Harnett County
420 McKinney Pkwy
LILLINGTON, NC 27546
Phone:
Fax:

SUBJECT: **BRES2301-0075**
BUILDING RESIDENTIAL

Here are the results of all Inspections located at **1231 MURCHISONTOWN RD:**

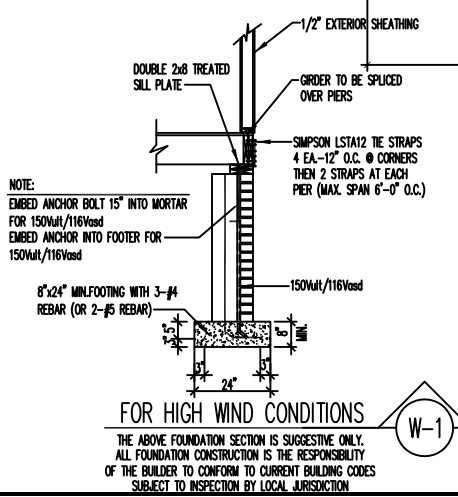
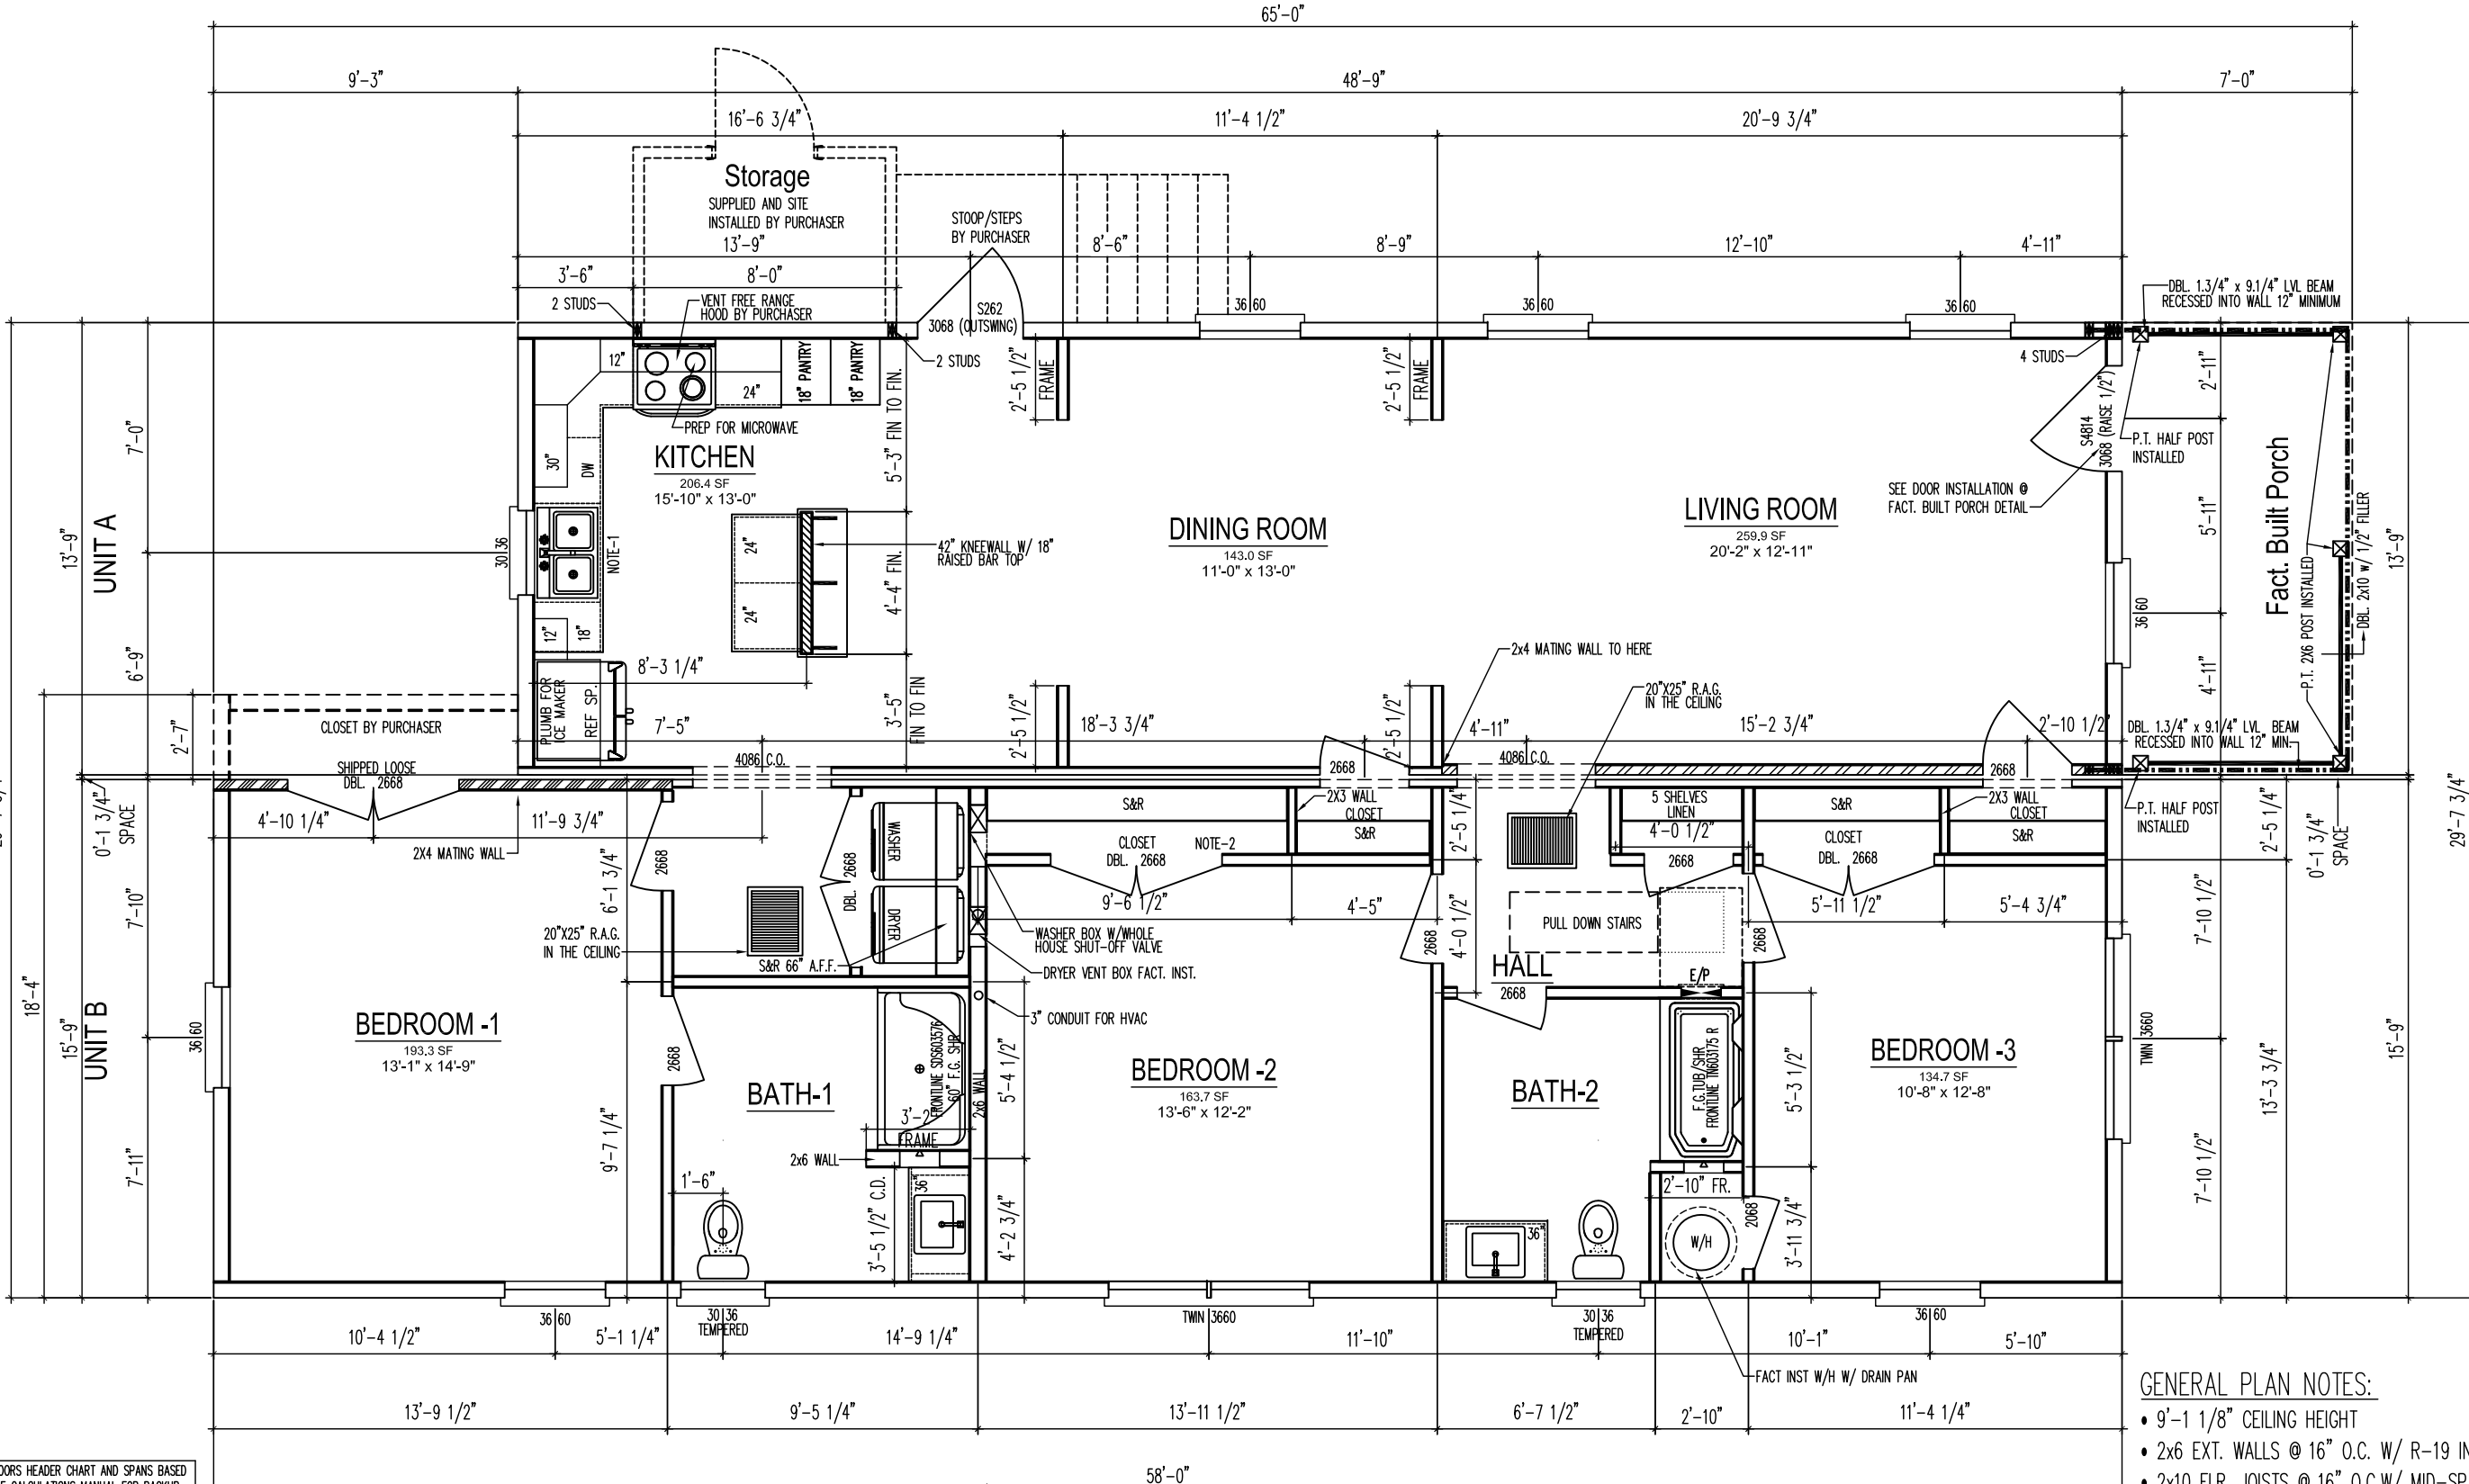
Inspection Type: FOUNDATION
Scheduled Date/Time: 12/5/2024
Completed Date/Time: 12/5/2024
Inspector: Ricardo D Honrada
Result: DISAPPROVED
Remarks:
Notes: Uncover the top of walls footings and pier's columns, to see the projections. Need anchor bolts ref. Code R403.1.6

**MATING WALL TENSION CONNECTION**

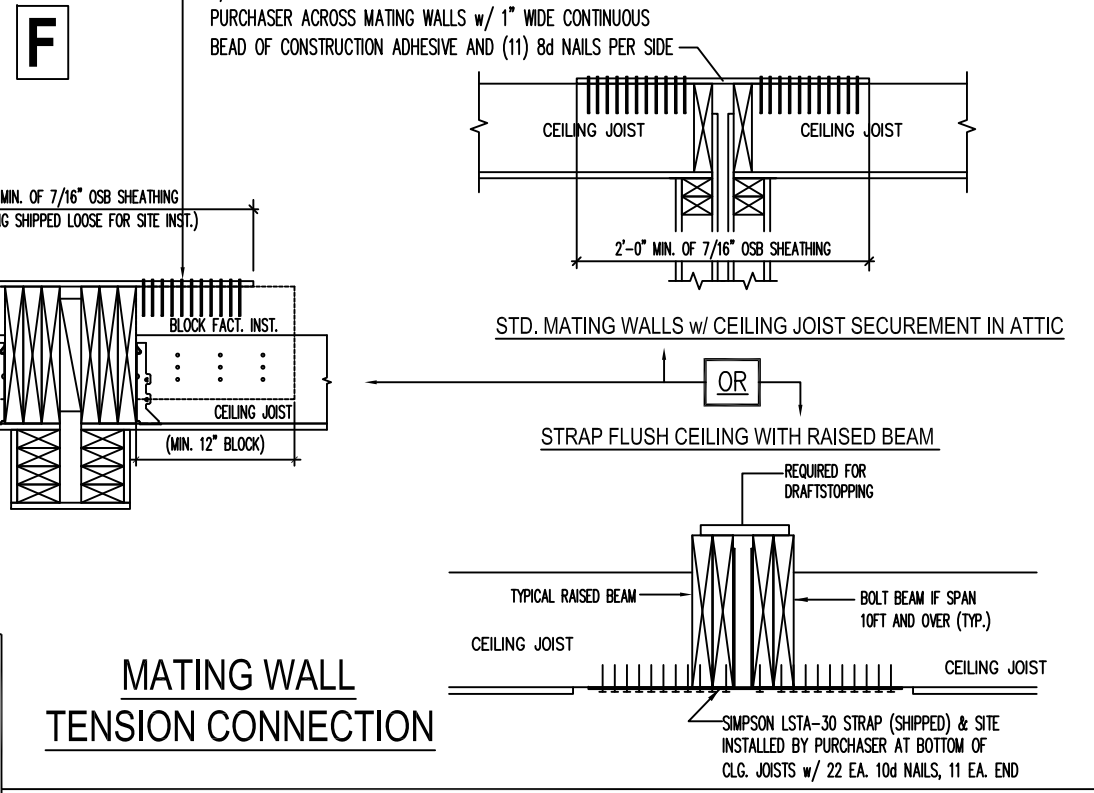
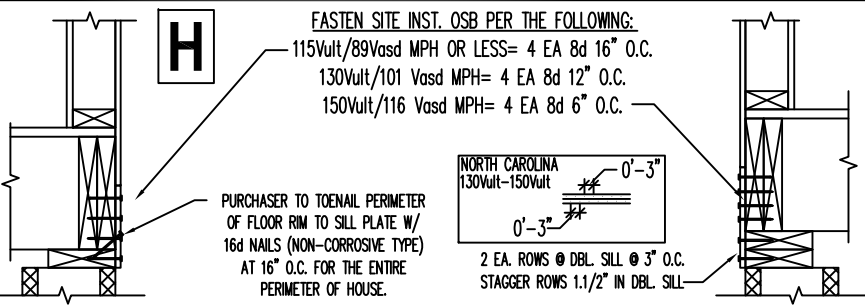
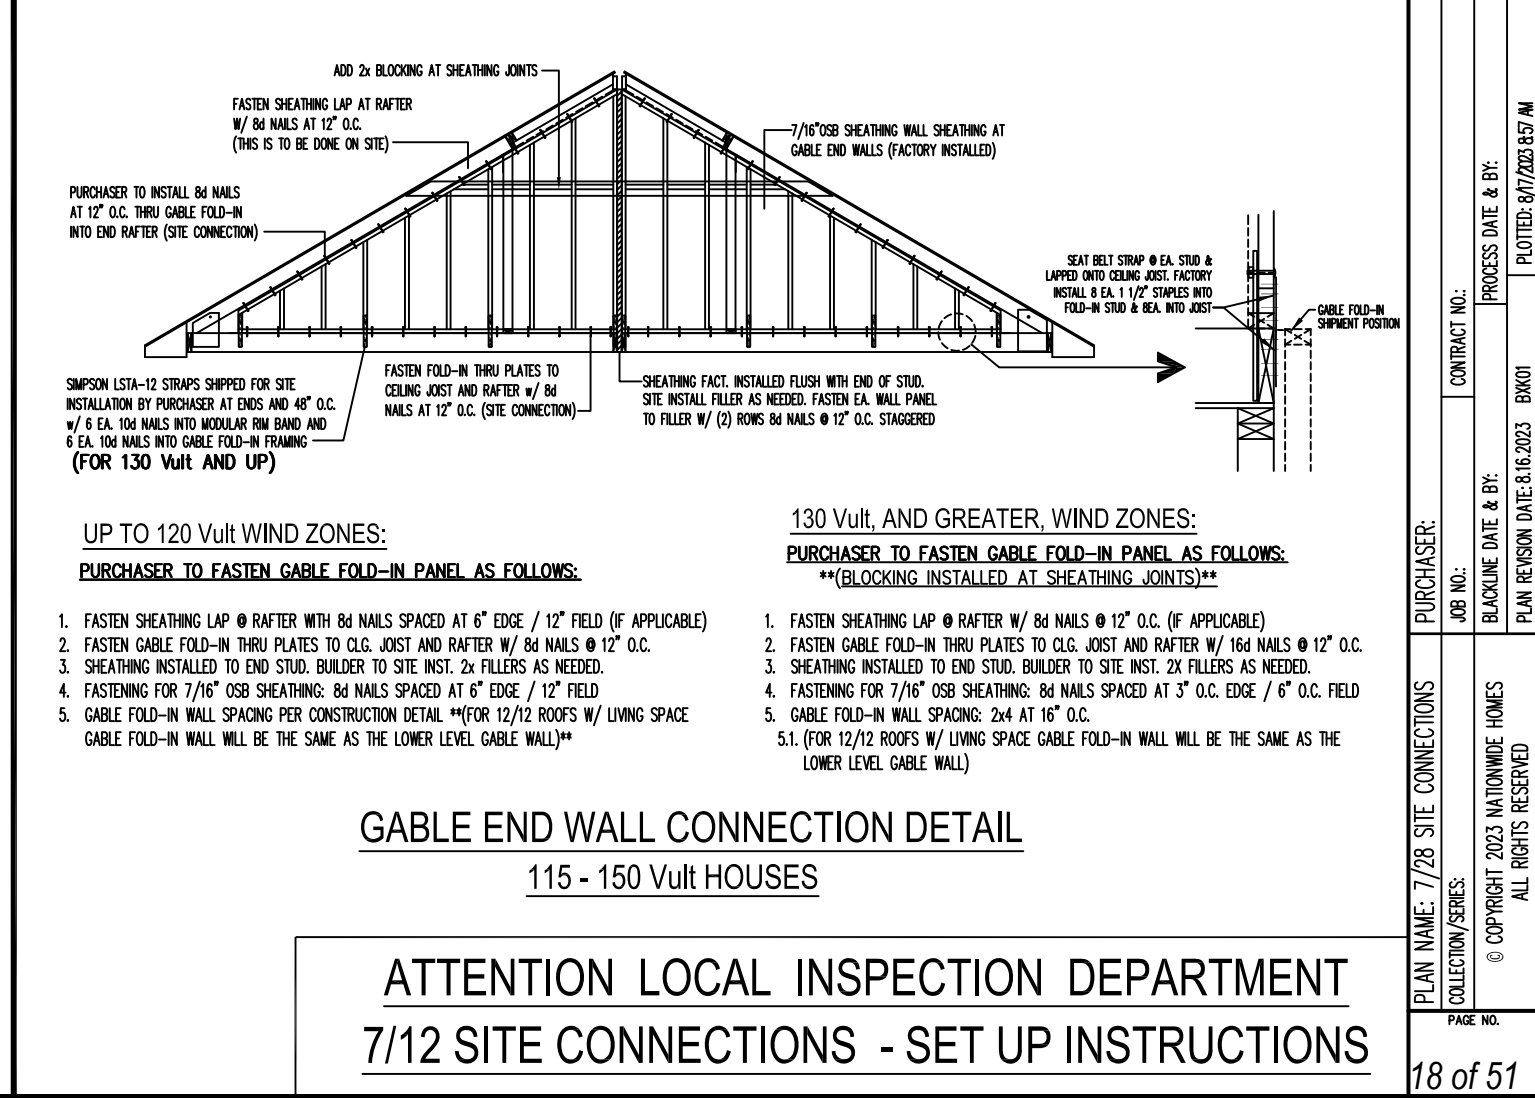
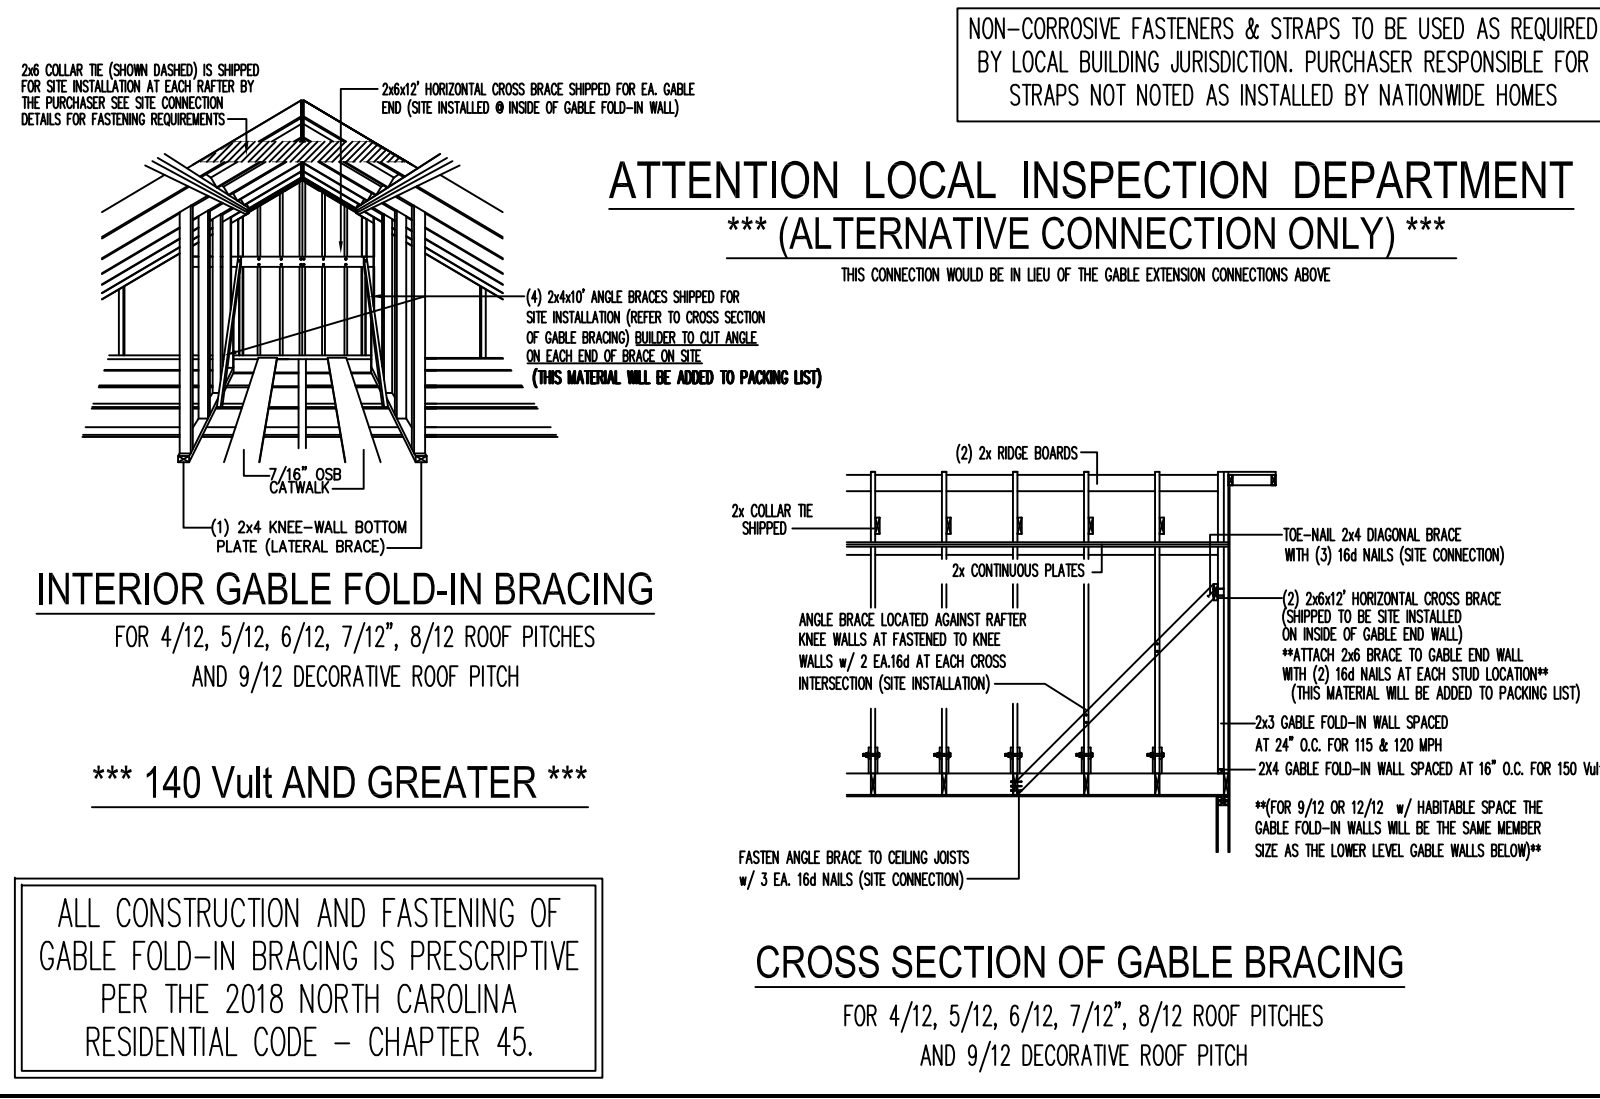
Inspection Type: MARRIAGE WALL
Scheduled Date/Time: 3/18/2025
Completed Date/Time: 3/18/2025
Inspector: Ricardo D Honrada
Result: DISAPPROVED
Remarks:
Notes: LOCK BOX 4760
Need follow as per plan detail H metting wall tension connection. Need portable toilet.
